Ribble Valley Borough Council
Church Walk,
Clitheroe,
BB7 2RA

Phone: 0300 123 6780
Email: lhscustomerservice@lancashire.gov.uk
Your ref:
Our ref: LHS/CS/3/2016/0374
Date: 30th June 2016

Proposal:	Erection of 9 dwellings and associated works
Location:	Land to the East of Clitheroe Road Barrow BB7 9BN
Grid Ref:

Street scene along Site Entrance (Section B-B)

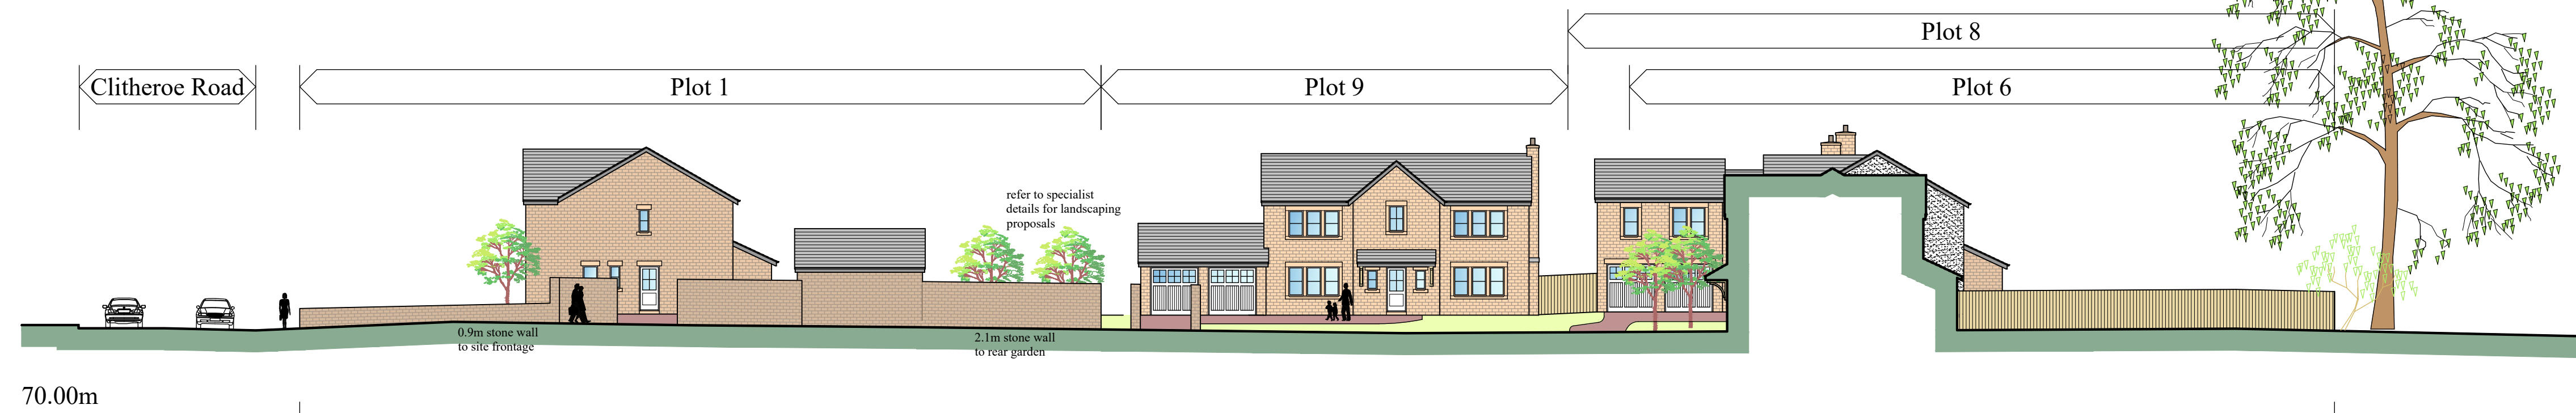
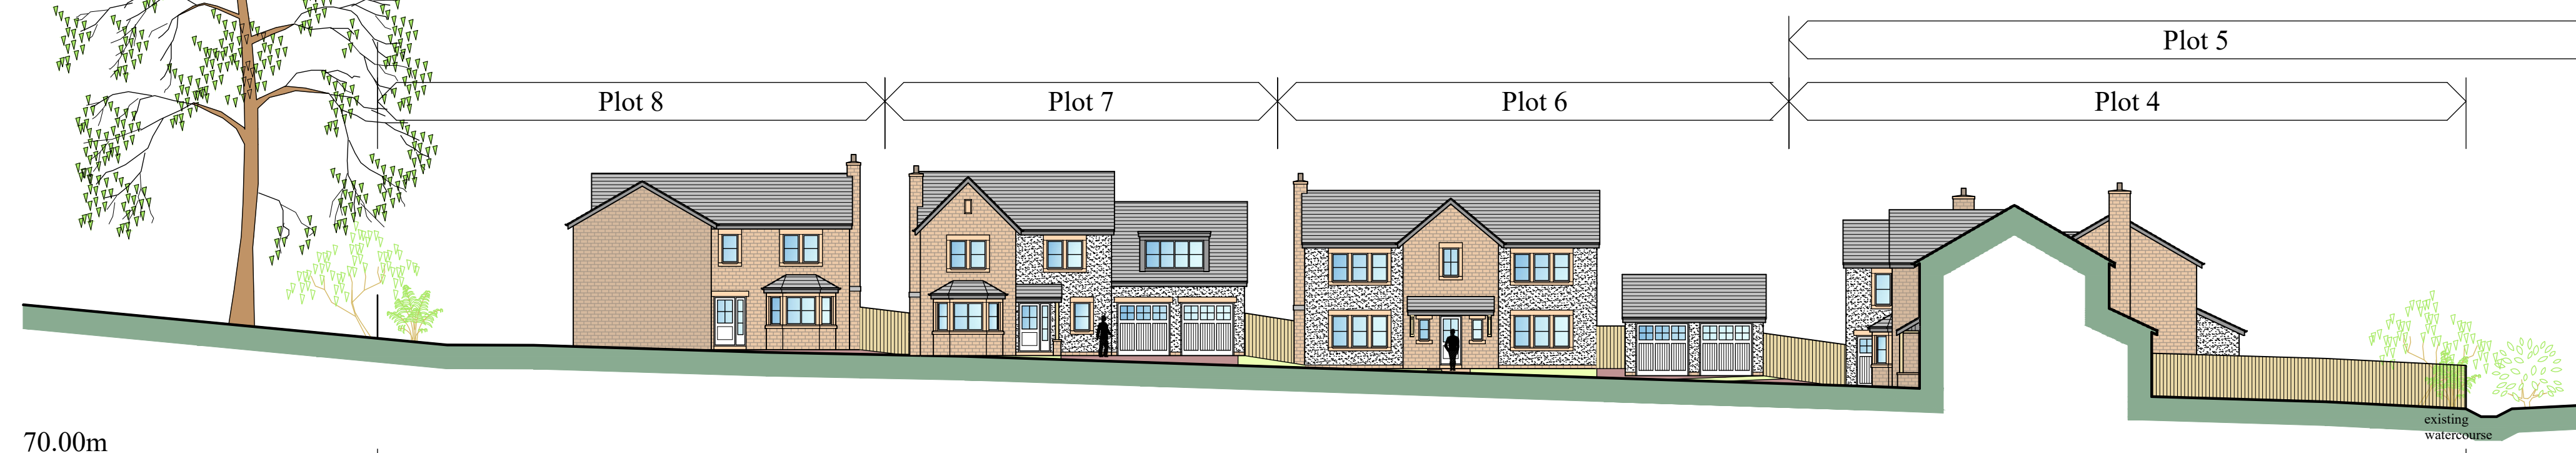
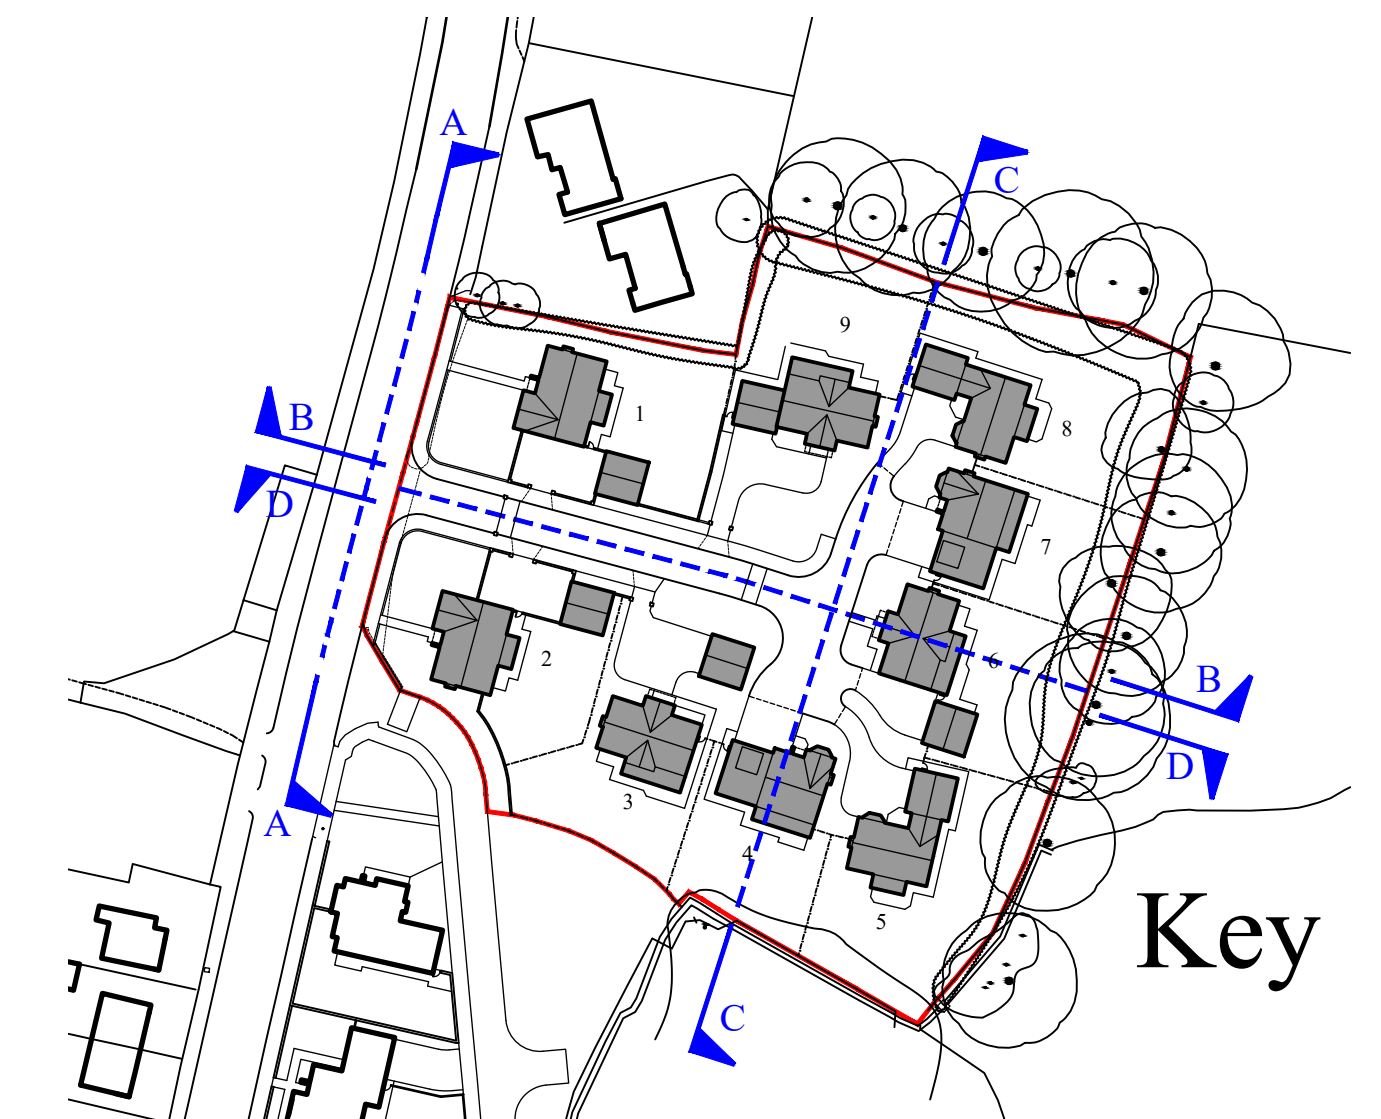
The Highway Development Control Section is of the opinion that the shown sight lines of 2.4x60m are acceptable in this location due to the width of Clitheroe Road (approx. 8.35m) and the achievable sight lines to the north are greater than show.

The Highway Development Control Section fully supports the proposal to provide a 2m wide footpath along the full frontage of the site with Clitheroe Road, to support sustainable forms of transport and the promotion of social inclusion.

The new site access and off-site works (2m wide footpath, along the frontage of Clitheroe Road) will need to be constructed under a section 278 agreement of the 1980 Highways Act. The Highway Authority hereby reserves the right to provide the highway works within the highway associated with this proposal. Provision of the highway works includes design, procurement of the work by contract and supervision of the works. The applicant is advised to contact the Environment Directorate before works begin on site. Further information and advice can be found at www.lancashire.gov.uk and search for 278 agreement.

3. No part of the development shall be commenced until the visibility splays measuring 2.4 metres by 60 metres in both directions to be provided, measured along the centre line of the proposed new road from the continuation of the nearer edge of the existing carriageway of Clitheroe Road, to the satisfaction of the Local Planning Authority. The land within these splays shall be maintained thereafter, free from obstructions such as walls, fences, trees, hedges, shrubs, ground growth or other structures within the splays in excess of 1.0 metre in height above the height at the centre line of the adjacent carriageway.
Reason: To ensure adequate visibility at the street junction or site access in the interest of highway safety in accordance with Quality of Development Policy and Transport Policy in the Local Plan.
